Recommendation Report for Planning Permission for Works or Extension to a Dwelling

REF NO: AW/91/21/HH

LOCATION: 2 The Byeway
Aldwick
PO21 4ER

PROPOSAL: Loft extension, first floor terrace extension with alterations to fenestration and extension to patio (This application may affect the setting of the Aldwick Bay Conservation Area).

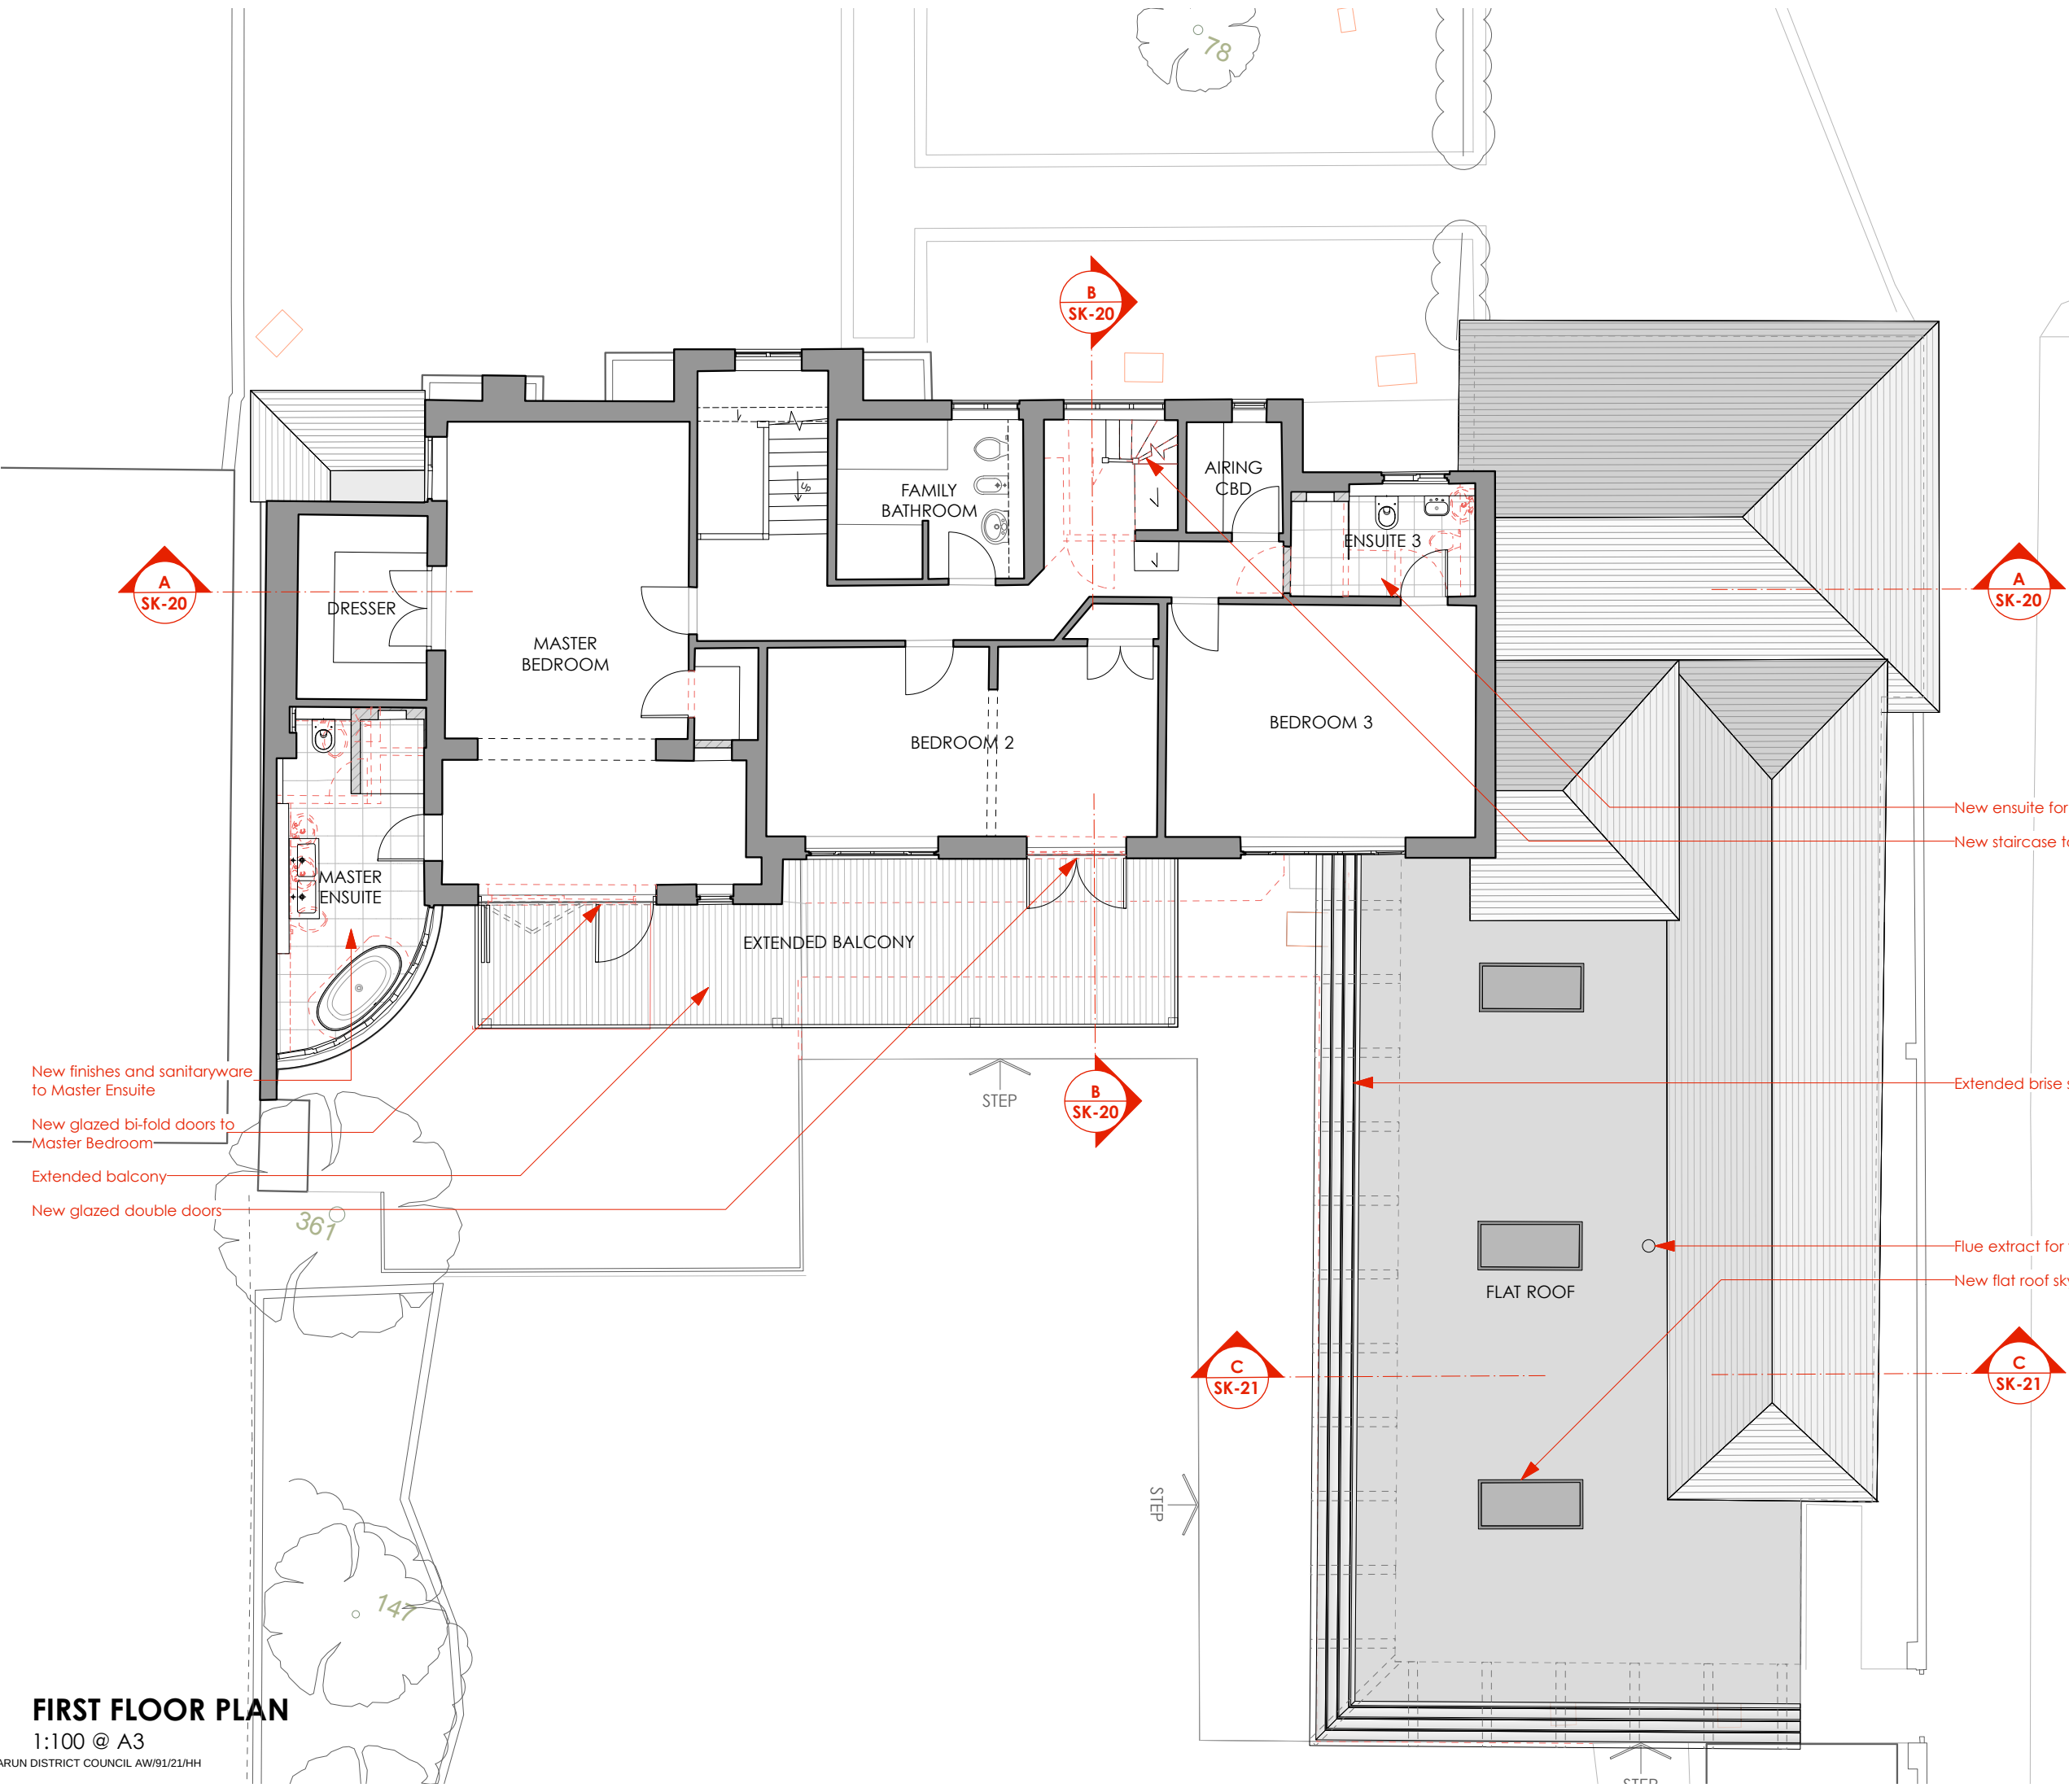
The extensions to the balcony at first and second floor level are in the centre of the dwelling with built form on either side of it preventing any adverse overlooking. The second floor loft extension is like wise located centrally and will avoid any adverse overlooking.
